Applicant: Kevin Braune
Owners:
Address: 76 Rarner Rd, Cliff Island

Date: Dec. 22, 2014

CHECK-LIST AGAINST ZONING ORDINANCE

Proposed Use/Work - raise existing 1st floor to meet base flood elevation (two feet above)

A1.3

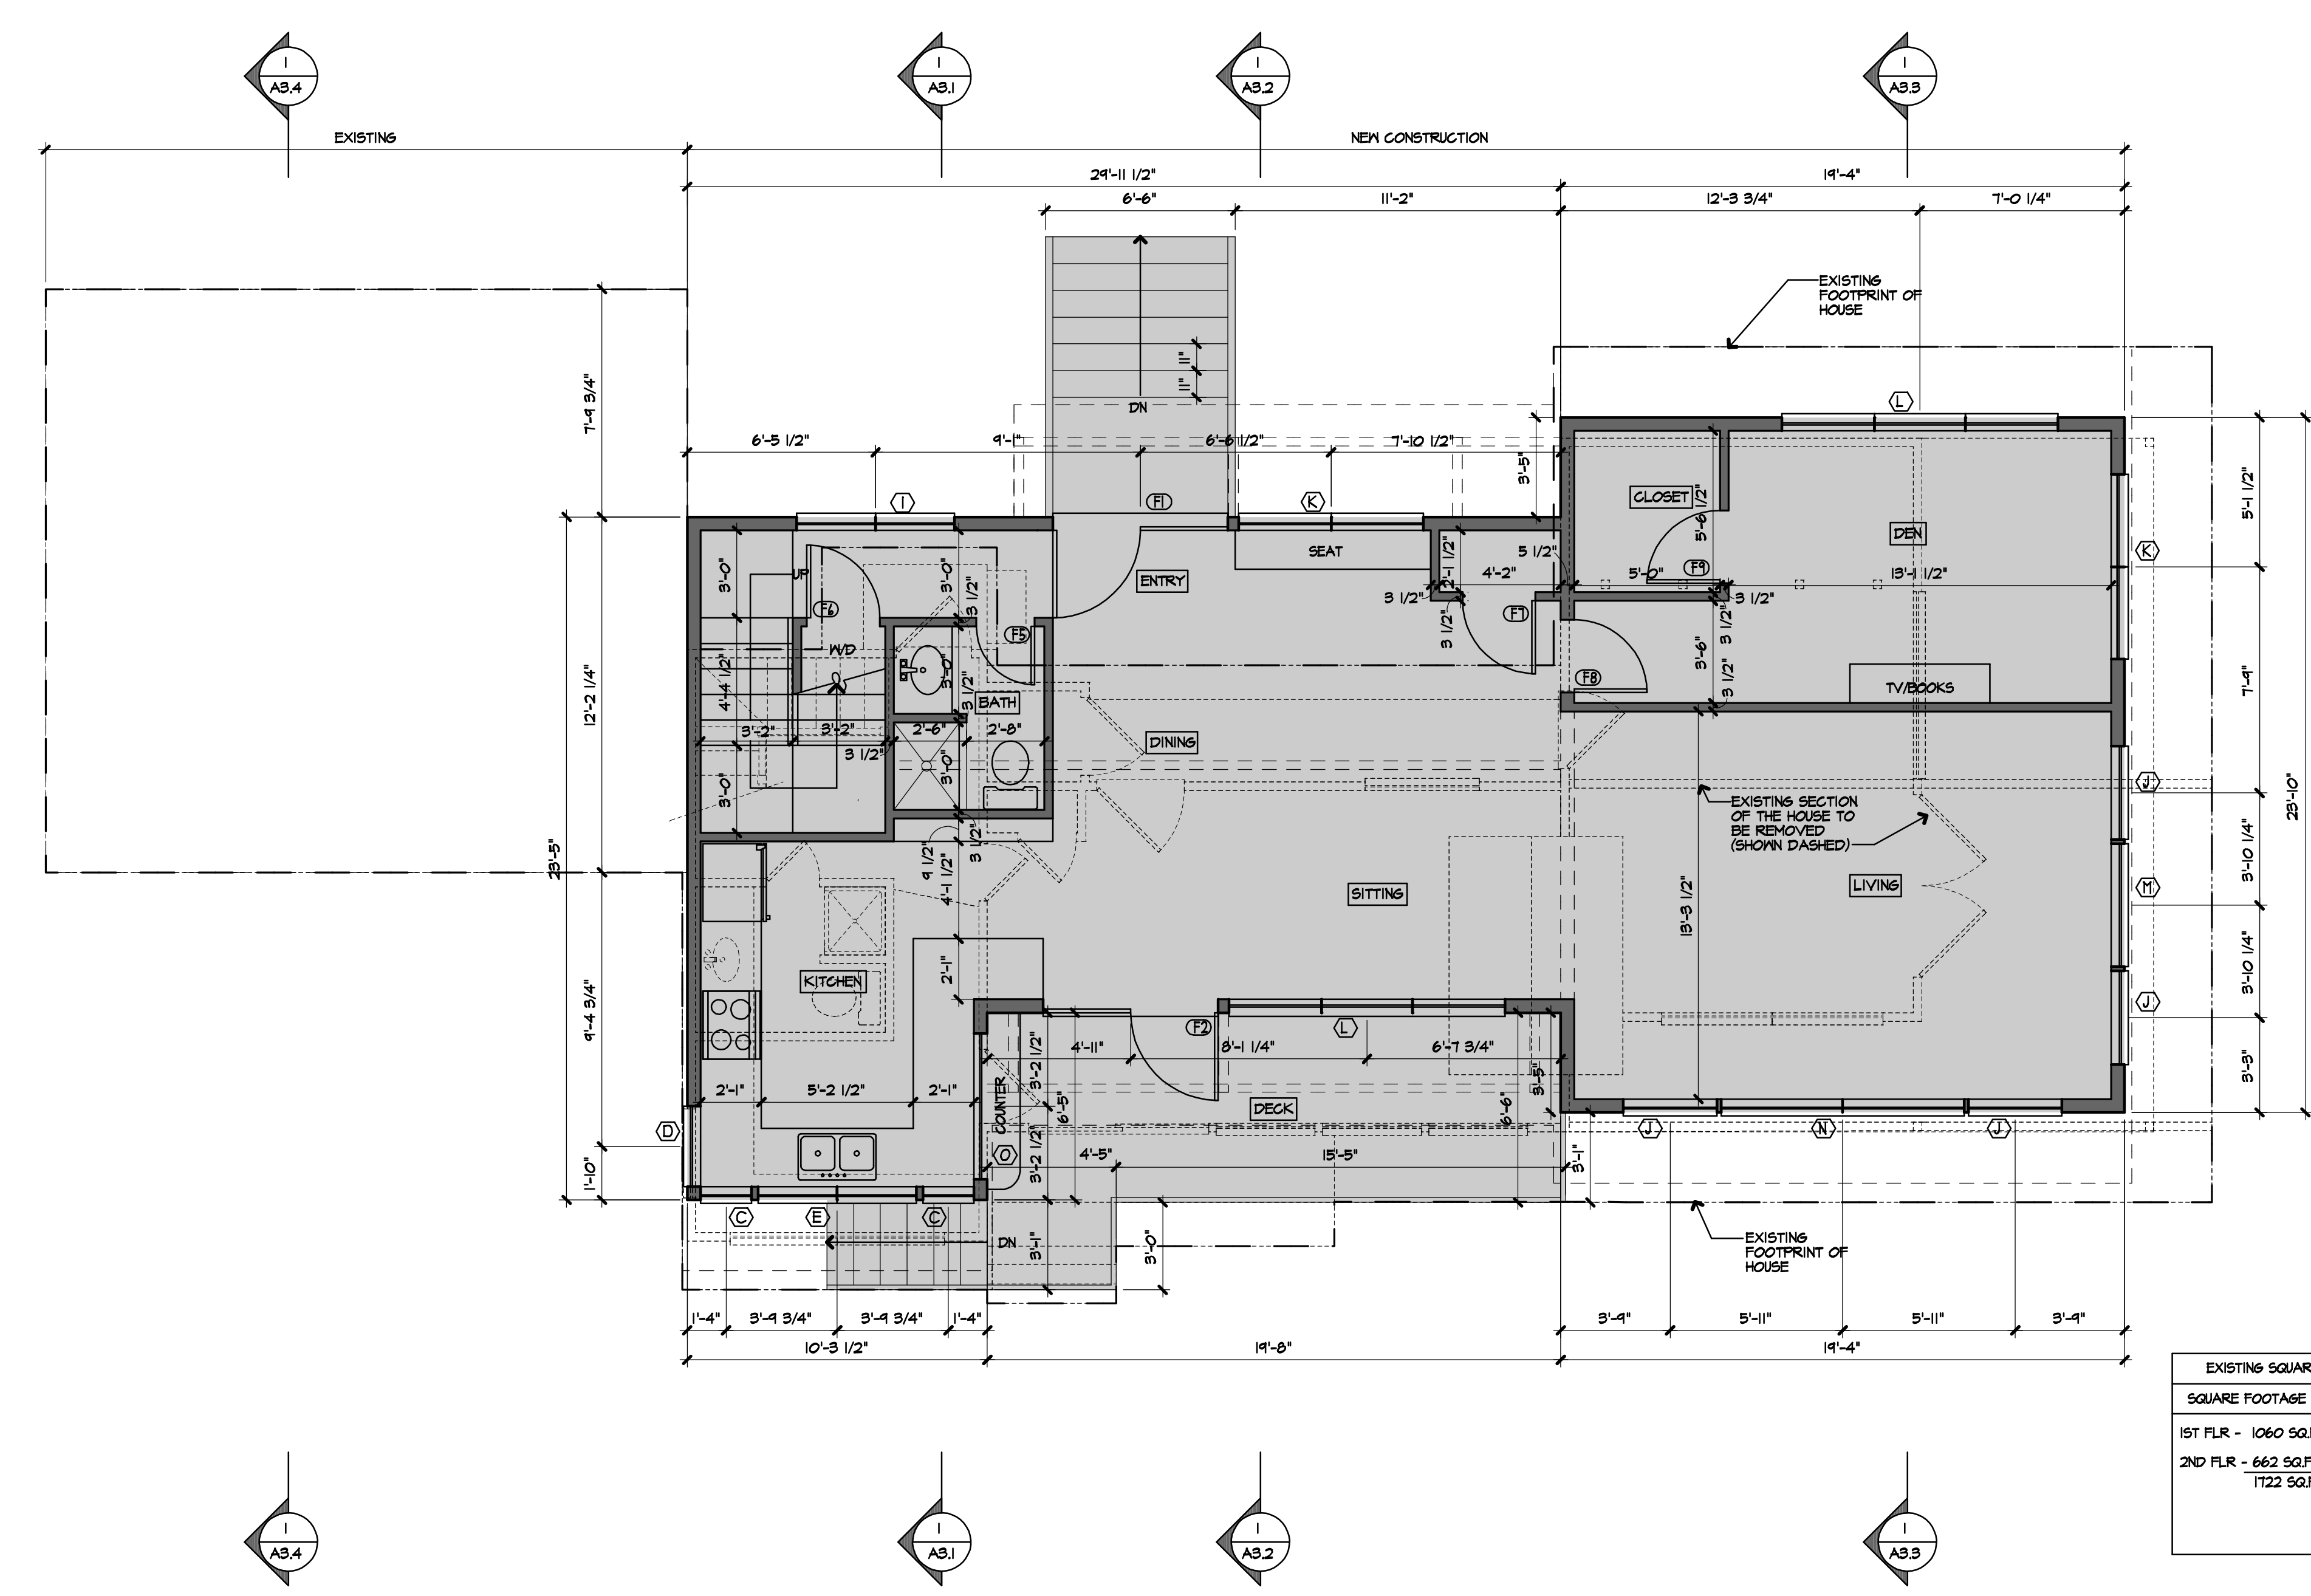
existing floor area 1722 sq ft

proposed " ~~1722~~ 2238 sq ft

adding 516 sq ft - 29.99%

existing volume - 16,575 cu. ft.

proposed volume - 21,533 cu. ft.

adding 4958 cu. ft. 29.9% OK.
